From: Damian Sullivan
Sent: 12 November 2013 14:51
To: Delwyn Jones
Subject: LY/20/13/CLP Almond Cottage, The Causeway, Arundel

PROPOSED ELEVATIONS

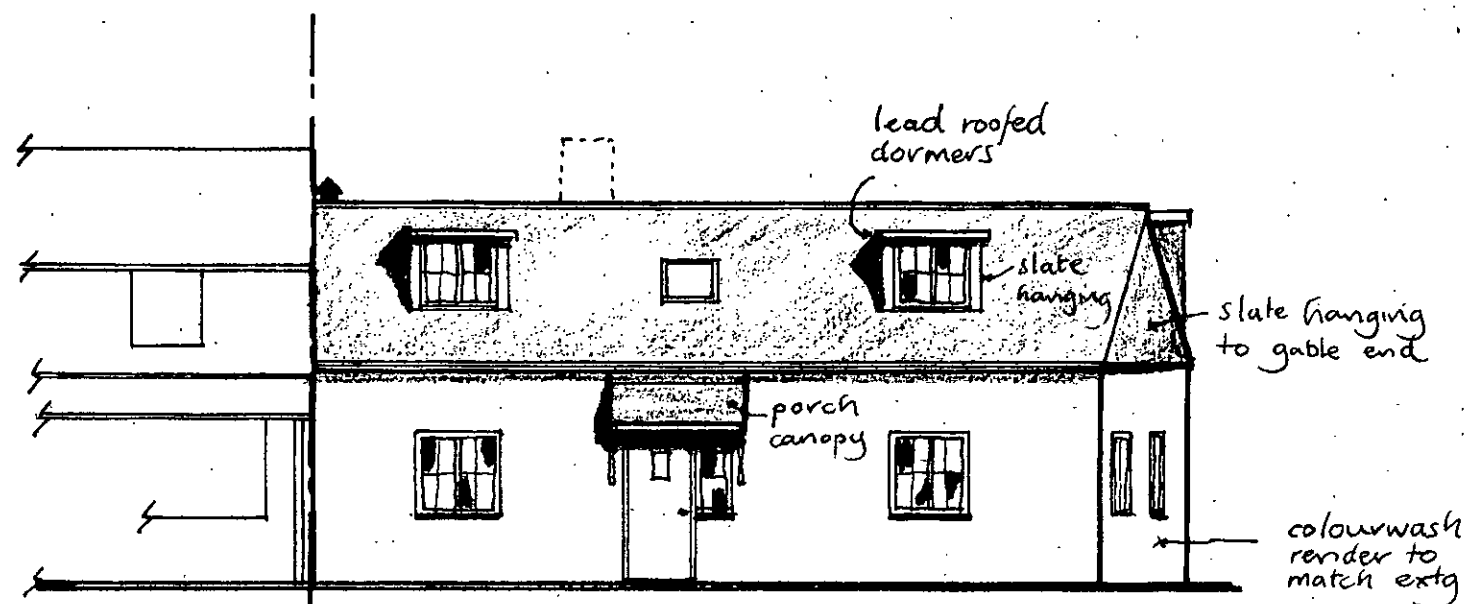
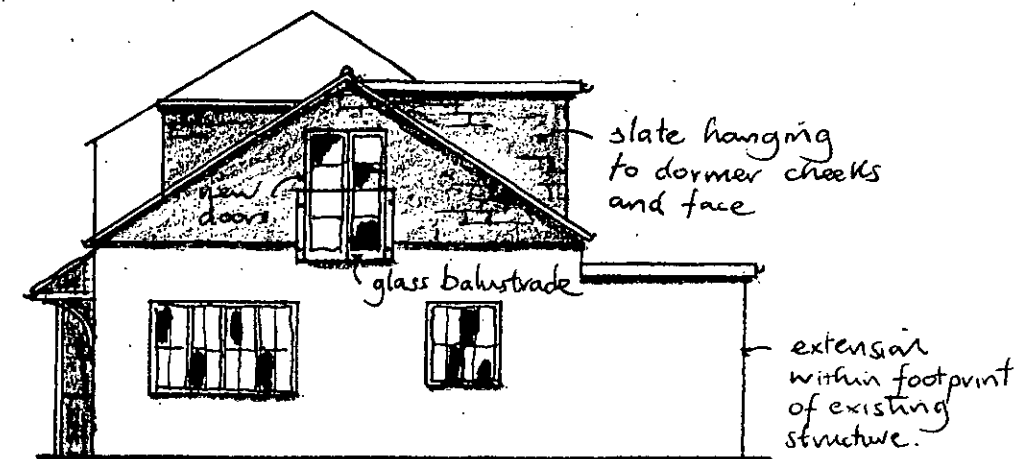
The reason for asking is that it has a bearing on whether the front dormers face a highway and so require planning permission. Under (2) of the definition, I would suggest that the road outside is a highway. The deadline for comments if you can make it is 18th November 2013.
